**KIRKLEES METROPOLITAN COUNCIL
INVESTMENT & REGENERATION SERVICE**

DELEGATED DECISION TO DETERMINE PLANNING APPLICATIONS

Reference No:	2024/62/92303/E
Site Address:	74, Station Lane, Birkenshaw, BD11 2JE
Description:	Erection of single and two storey rear extension and detached garden room
Recommending Officer:	Edward Cheseldine

DECISION – Conditional Full Permission

1 GROUND FLOOR AS PROPOSED
SCALE 1:50

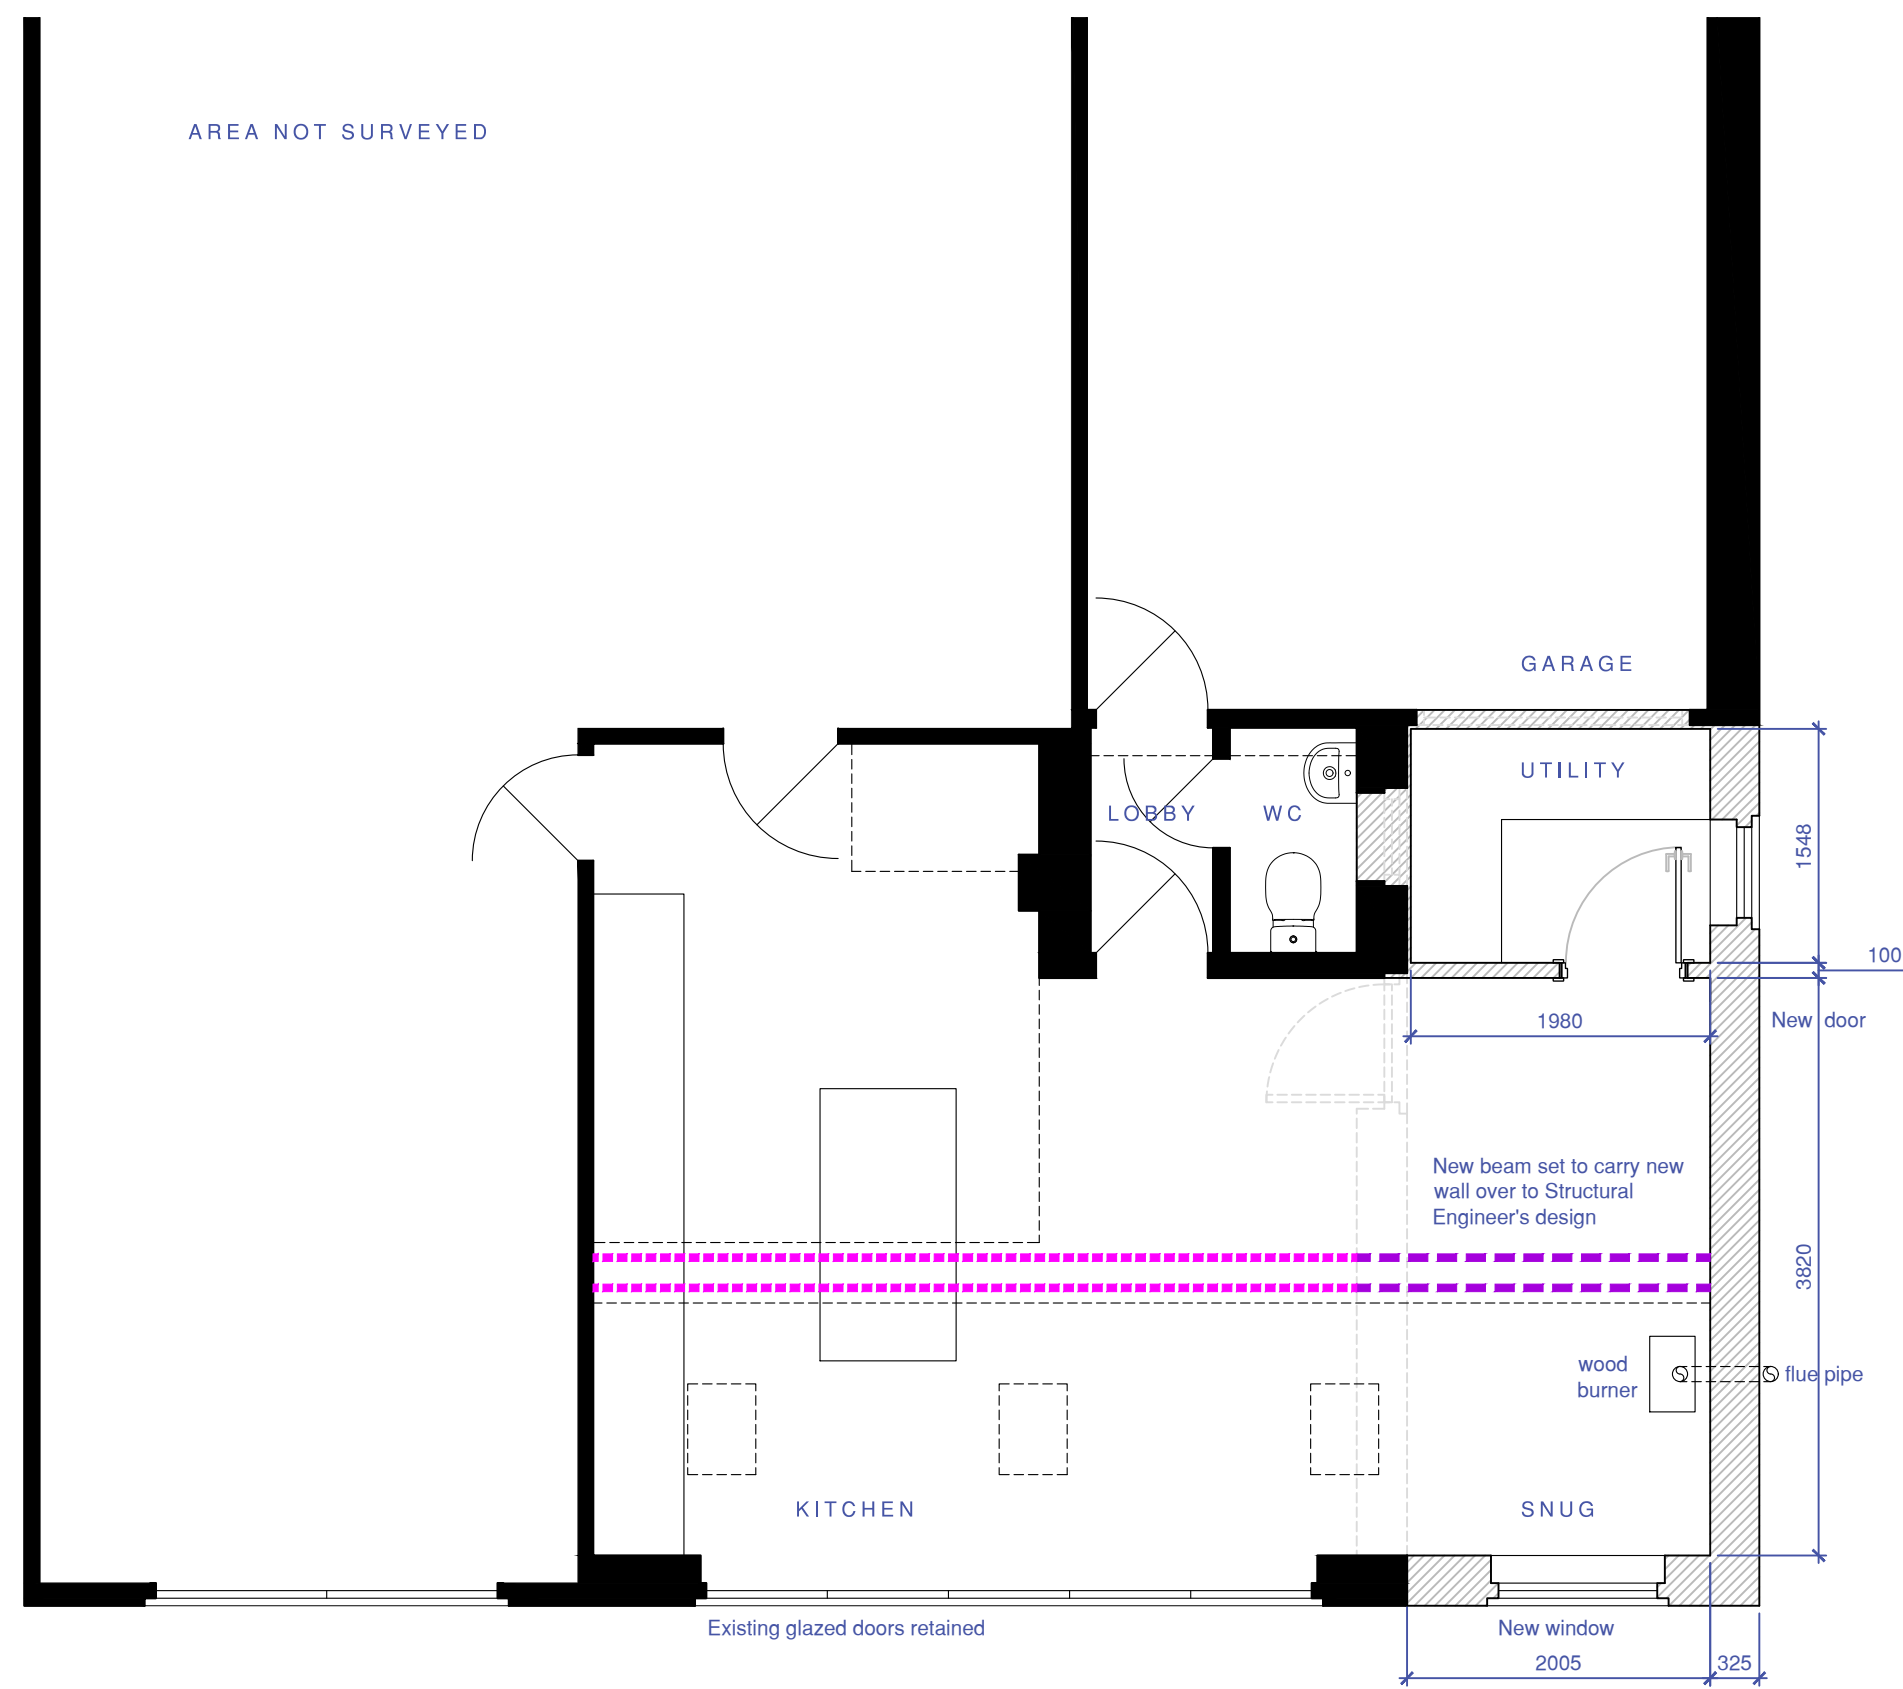
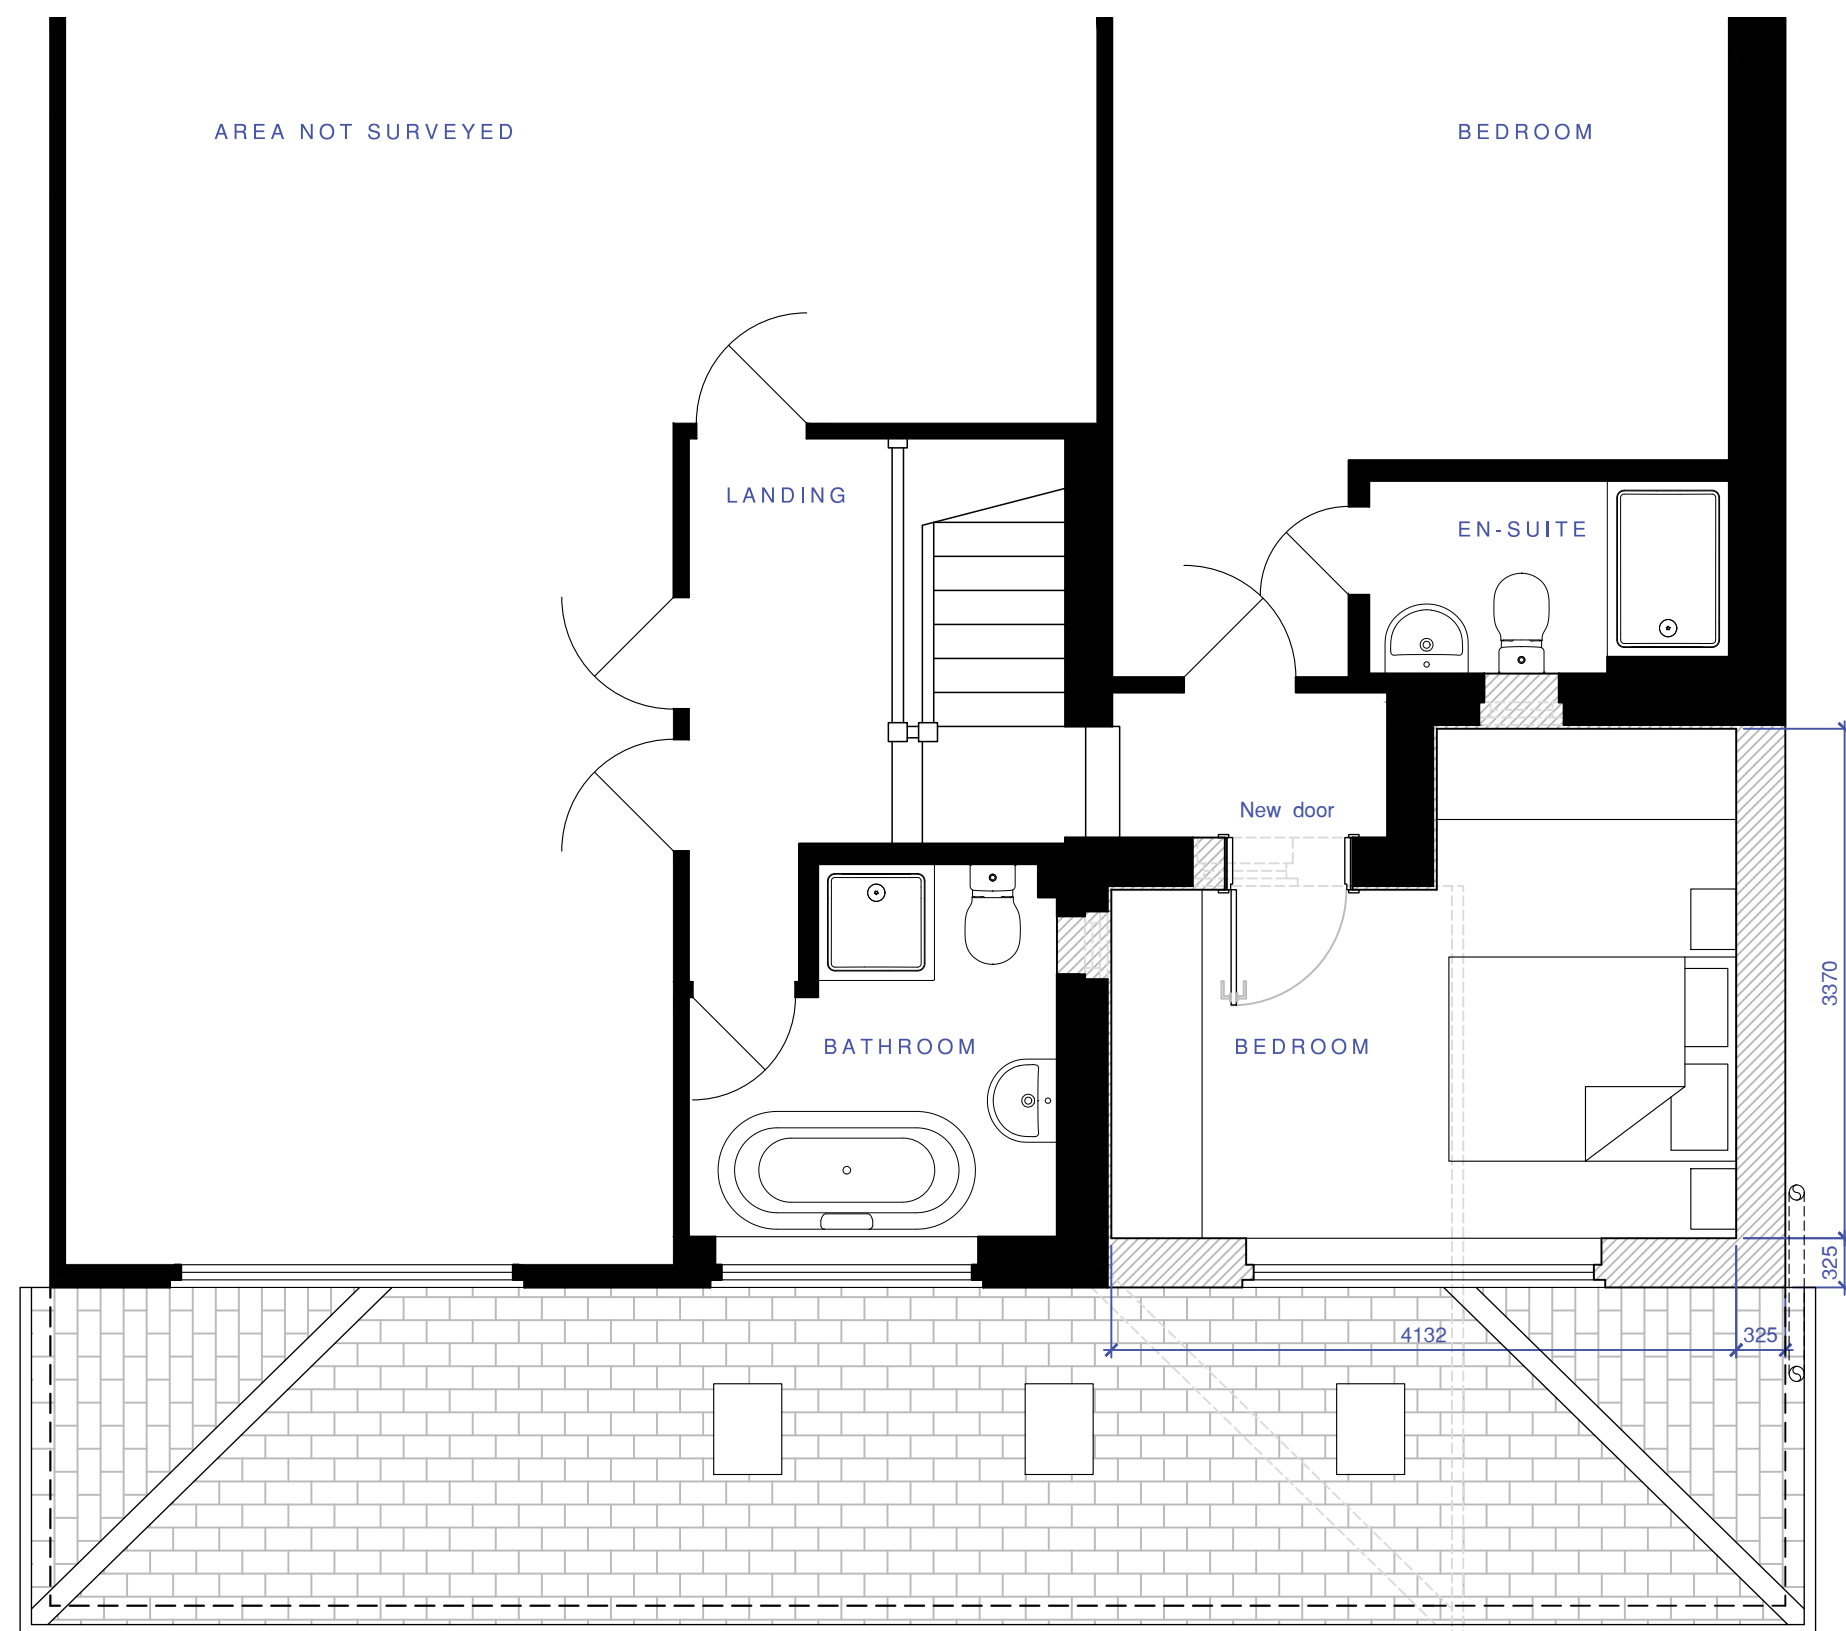
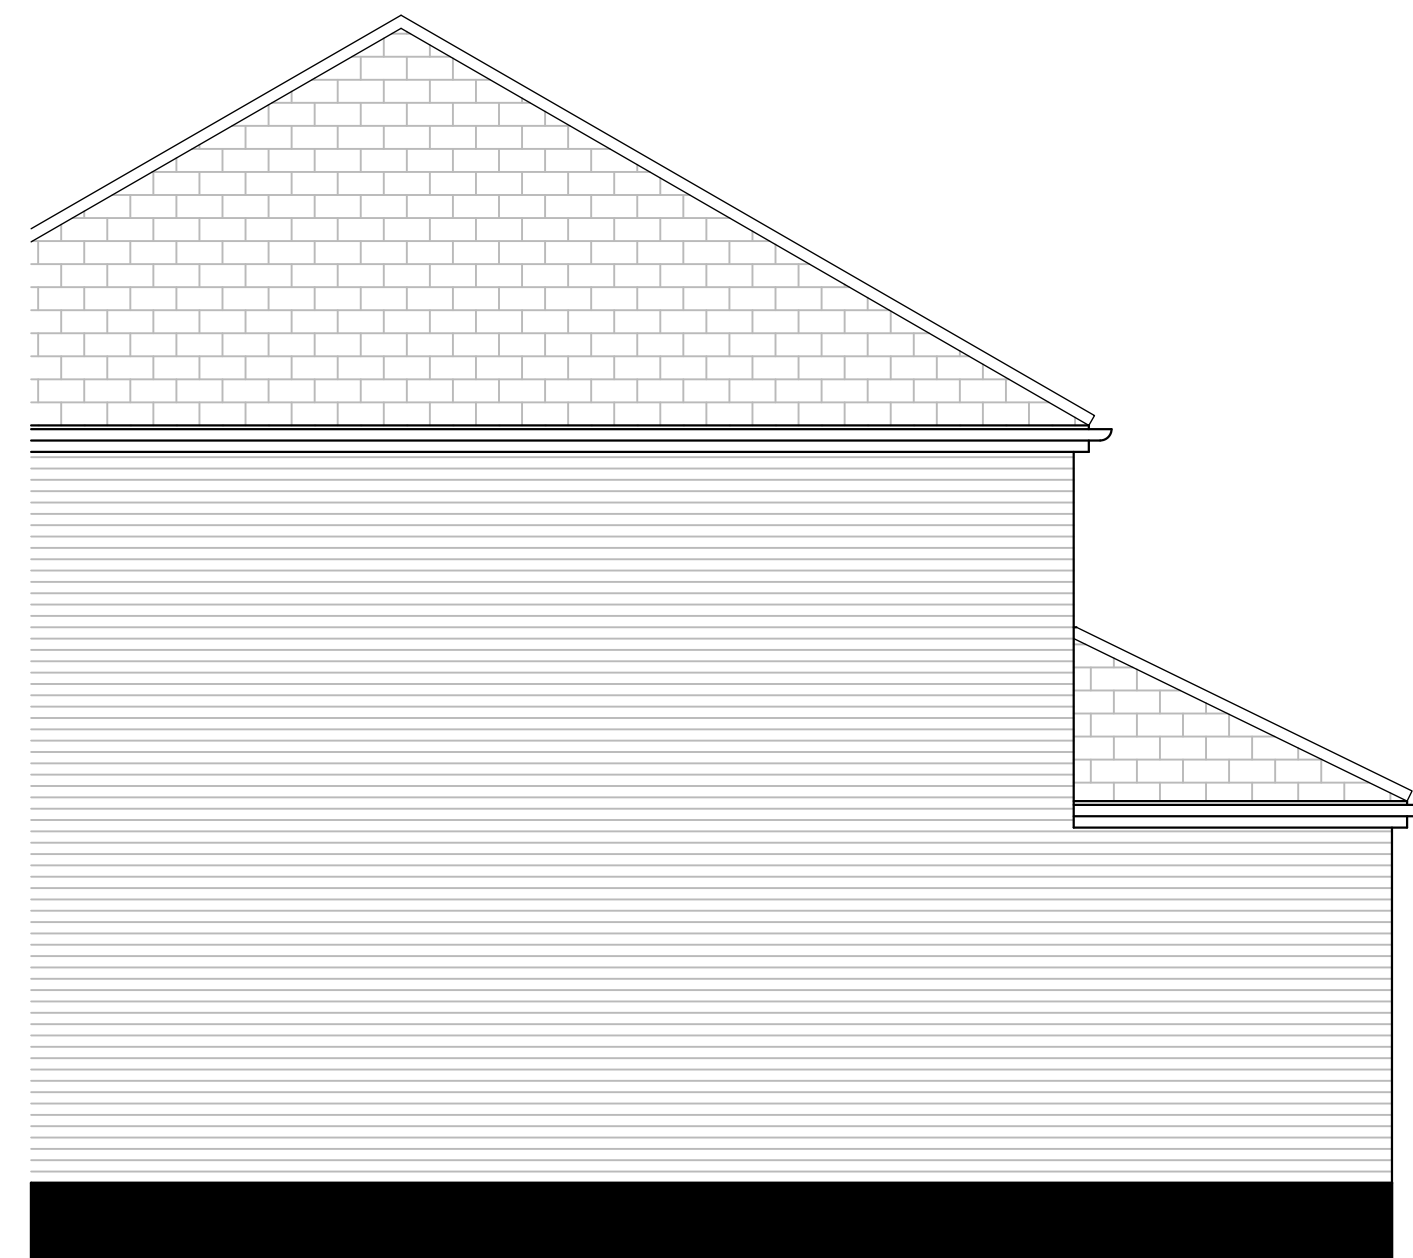
<u>Yes - COMPLY</u>	<u>No - JUSTIFY</u>
Be in keeping with the scale and style of the original house	The extension will form an 'infill' to a previous extension. In this case, the principle has therefore already been established. The additions will form a rectangular footprint with materials to match the existing dwelling which is in keeping with the original design of the property.	
Not normally cover more than half the total area around the original house (including previous extensions and outbuildings)		When including the outbuilding, the existing and proposed extensions will be greater than half the total footprint of the house. The outbuilding is visually separate from the main dwelling. The plot is a large residential area, the additions to the dwelling will provide a 'infill' extension. It is not considered that the additions would result in a negative impact to the original dwelling.

Not exceed 4 metres in height		The extension would have an eaves height of ~5.00m .it would meet the eaves of the original dwelling and is acceptable in this instance.

Relevant key design principle (KDP) of the SPD, Policy in the Kirklees Local Plan and the NPPF	Further comments	✓ / X / N/A
Impact on the Local character and street scene	• KDP1 of the SPD • Policy LP24 Design (a) and (c) of the KLP • Chapter 12 NPPF	The extensions are to the rear of the property and are respectable in scale to nearby dwellings, therefore there will be no impact to local character.	✓
Impact on original house	• KDP2 of the SPD • Policy LP24 Design (c) and (d) of the KLP • Chapter 12 of the NPPF	The rear extension will form an 'infill' extension that will complete the appearance of the dwelling. In terms of the outbuilding, the materials are modern in appearance and whilst they do not match the host dwelling, considering it is an independent structure the appearance does not contribute to a change of character to the original house.	✓
Height, scale and massing	• KDP 1 and 2 of the SPD • Policy LP24 Design (a), (c) and (d) of the KLP	The scale is relative to the existing dwelling, previous extension and plot. The height of the rear extension will match the host dwelling.	✓

Impact on privacy of neighbours (to sides, rear and front)	• KDP 3 & 4 of the SPD • Policy LP24 Design (d) (iv) • Chapter 12 of the NPPF	There will be rear facing windows on the new extension. They will have a view towards neighbouring, private outdoor space. Given the angle of outlook is indirect and the neighbouring dwelling overlooks the residential space of the application site to a degree, the relationship is acceptable. In terms of the outbuilding, it will have windows with an outlook from habitable rooms that face No. 76. There is a separation distance of 17.00m between habitable windows on the first-floor of No.76 and 13.60m from non-habitable windows. The House Extension and Alteration Supplementary Planning Document states in paragraph 4.10, <i>A minimum separation of: no less than 12 metres is recommended between windows of habitable rooms that face onto windows of a non-habitable room no less than 21 metres is recommended between facing windows of habitable rooms</i> In terms of habitable windows, the outlooks are set at an acute angle, there is a difference in floor levels, due to this,	✓

the relationship is acceptable.	
Impact on light, outlook and creating an overbearing impact to neighbours (to sides, rear and front)	• KDP 4, 5, 6 of the SPD • Policy LP24 Design (b) • Chapter 12 of the NPPF	There are side facing windows on the dwelling of No. 76, which are thought to light a W/C and a utility room. Whilst the relationship of the built form is close, the distance of separation is sufficient to allow a flow of light into the window. The side space is used as an access to the rear garden. Given the above, the development is not considered to be to the detriment of light or create an overbearing impact. The garden is currently bounded by a thick shrub border. The outbuilding is single storey in height, given this the outbuilding will not be overbearing to the neighbouring occupants.	✓
